KITTITAS COUNTY COMMUNITY DEVELOPMENT SERVICES

RE: Barnes Short Plat (SP-12-00008)

The Kittitas County Community Development Services Department has determined that the Barnes Short Plat (SP-12-00008) is a complete application and hereby grants *conditional preliminary approval* subject to the following conditions:

BARNES SHORT PLAT
KITTITAS COUNTY SHORT PLAT NO. SP-12-XXXXX
 A PORTION OF THE NE 1/4 SECTION 5, TOWNSHIP 16 NORTH, RANGE 20 EAST, W.M.,
 KITTITAS COUNTY, WASHINGTON

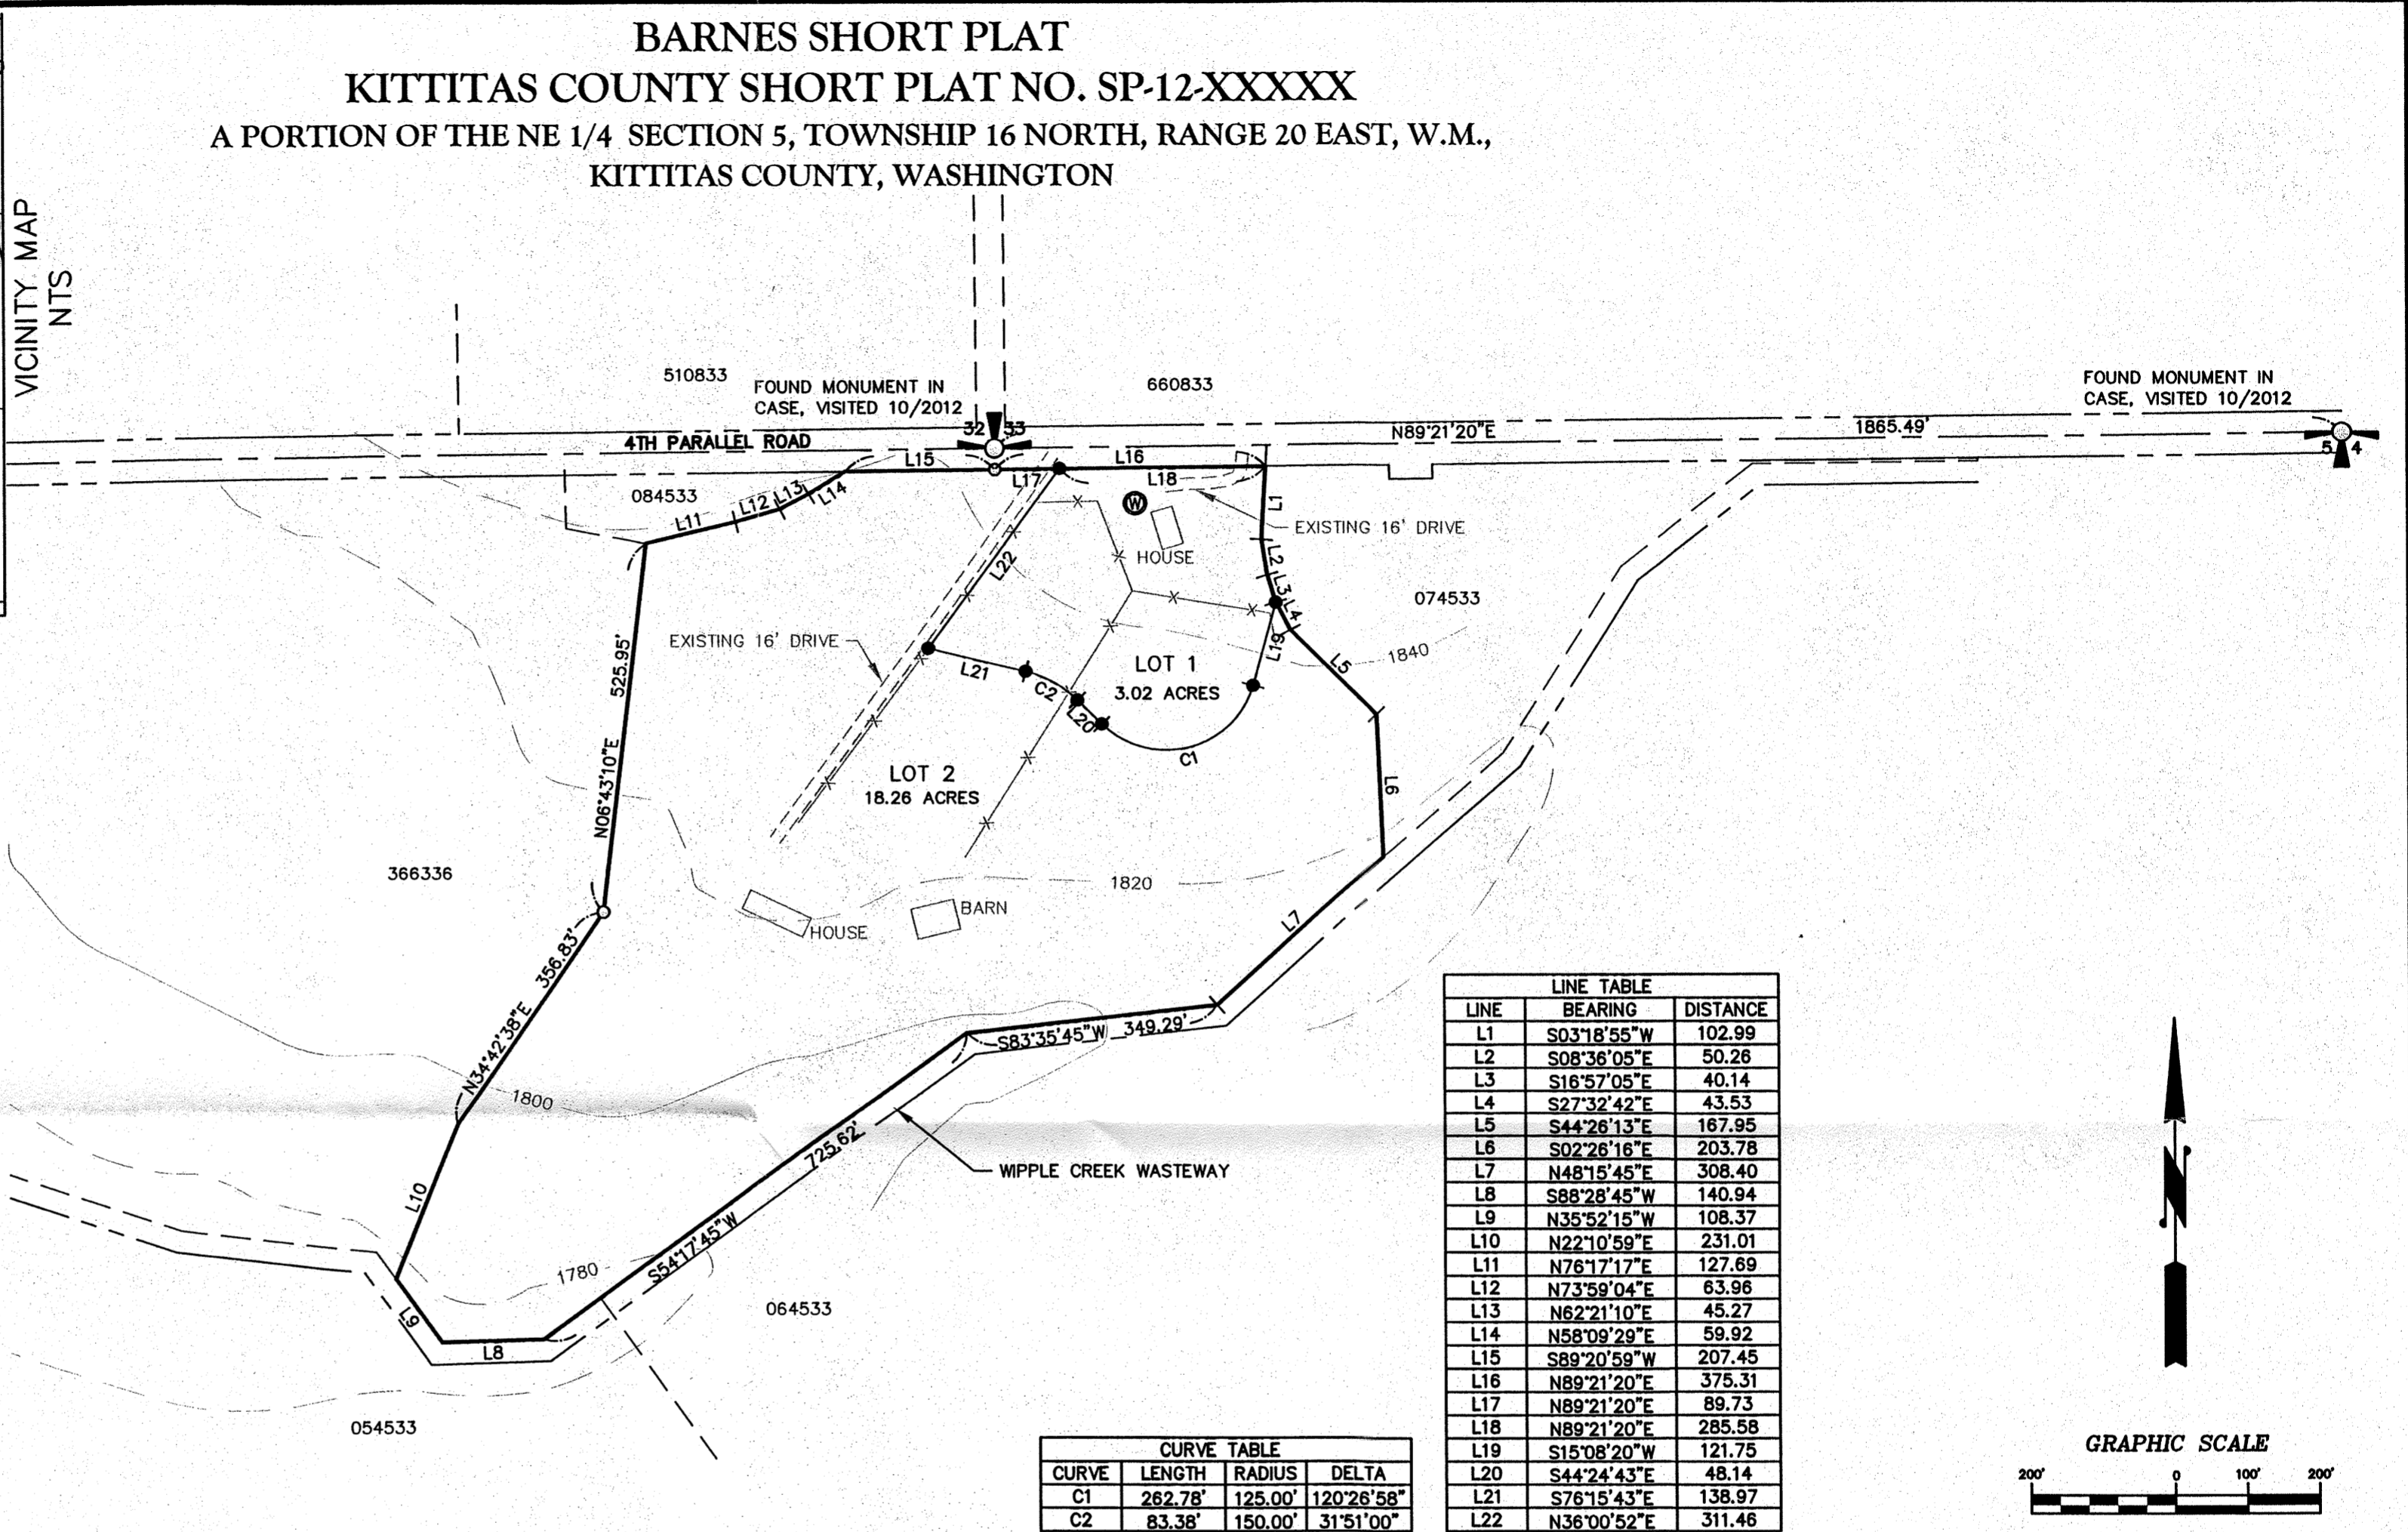
1. Both sheets of the final mylars shall reflect short plat number SP-12-00008 and an accurate legal description shall be shown on the face of the final plat.

5. A statement regarding the contemplated sewage disposal, water supply, and drainage improvements for the proposed subdivision shall be reflected on the final mylars.

12. The addresses shall be clearly visible from both directions at the County Road for all properties.
13. The Fire Department access road shall be capable of supporting 75,000 lbs in all weather, be 20' wide, provide 13'6" vertical clearance and provide for adequate turn-around for fire department apparatus.
